WEST SUSSEX COUNTY COUNCIL CONSULTATION

TO:	Arun District Council FAO: Anita Gardner
FROM:	WSCC - Highways Authority
DATE:	2 April 2019
LOCATION:	South Point 1 Beehive Lane Ferring BN12 5NL
SUBJECT:	FG/29/19/PL Erection of 1 No. 2 bed dwelling.
DATE OF SITE VISIT:	n/a
RECOMMENDATION:	Advice
S106 CONTRIBUTION TOTAL:	n/a

Proposed Site Plan, Location Plan,
and Context Plan

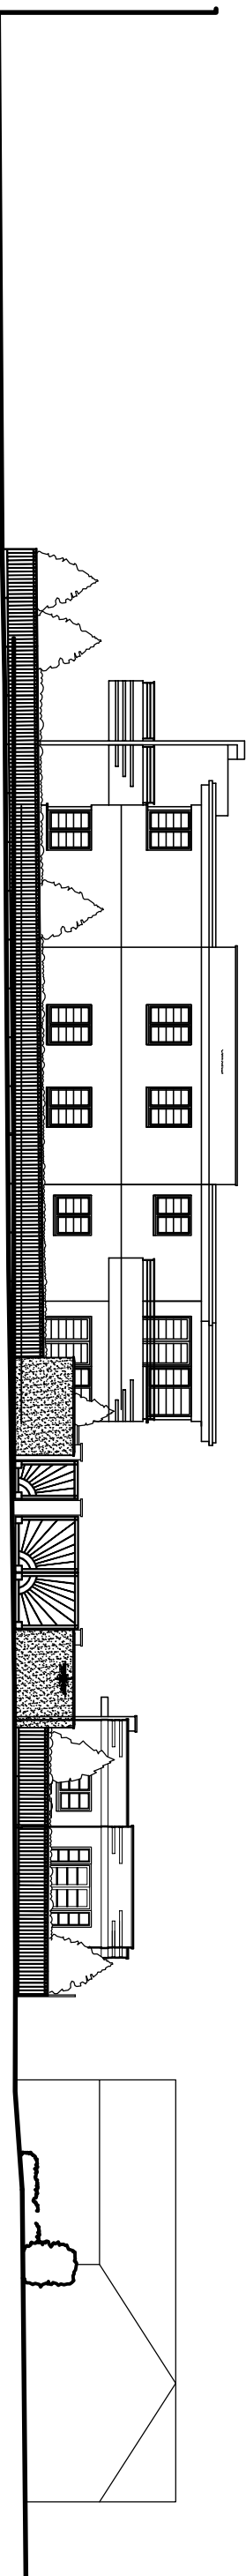
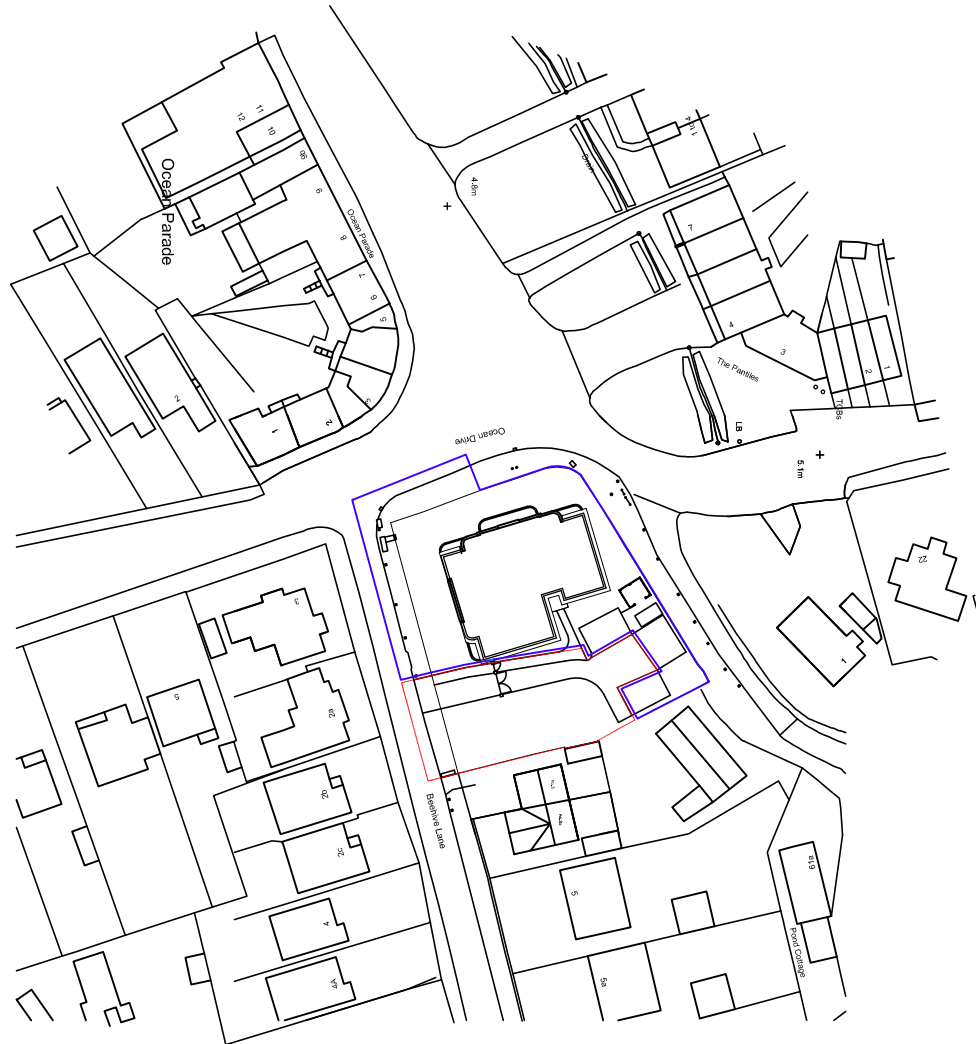
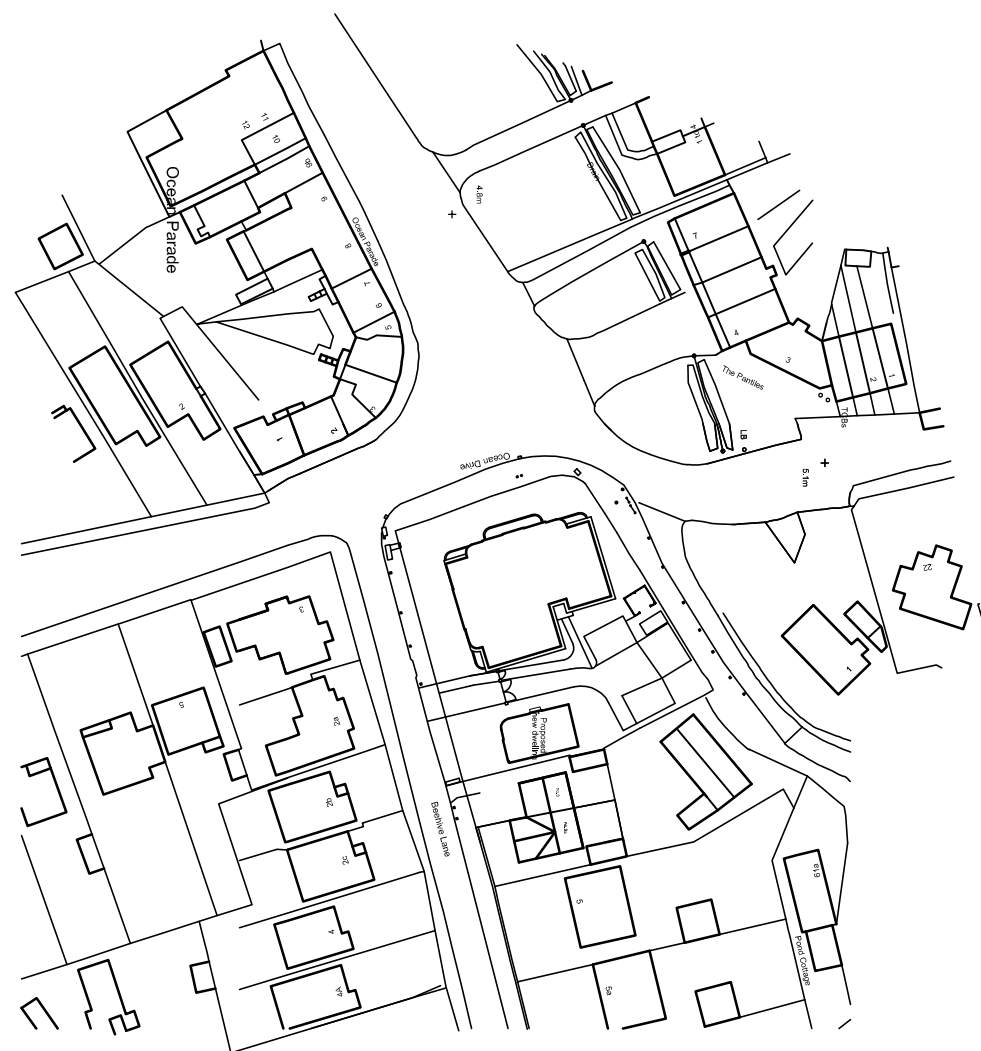
Upon inspection of the plans it is noted that the parking provision is using 1 parking space from the neighbouring flats. This would reduce the Approved parking plan down to 9 for this dwelling. Even though this would not generate any highways safety concerns, the Local Planning Authority may wish to consider amenity implications of additional on street car parking demand.

The site is located in a sustainable location within walking and cycling distance to a range of public services, amenities and employment options. Bus and rail links provide a realistic travel opportunity for longer trips. Due to this being the case, The Local

Highways Authority (LHA) would like to see covered, lockable cycle storage space being implemented.

No part of the development shall be first occupied until covered and secure cycle parking spaces have been provided in accordance with plans and details to be submitted to and approved by the Local Planning Authority.
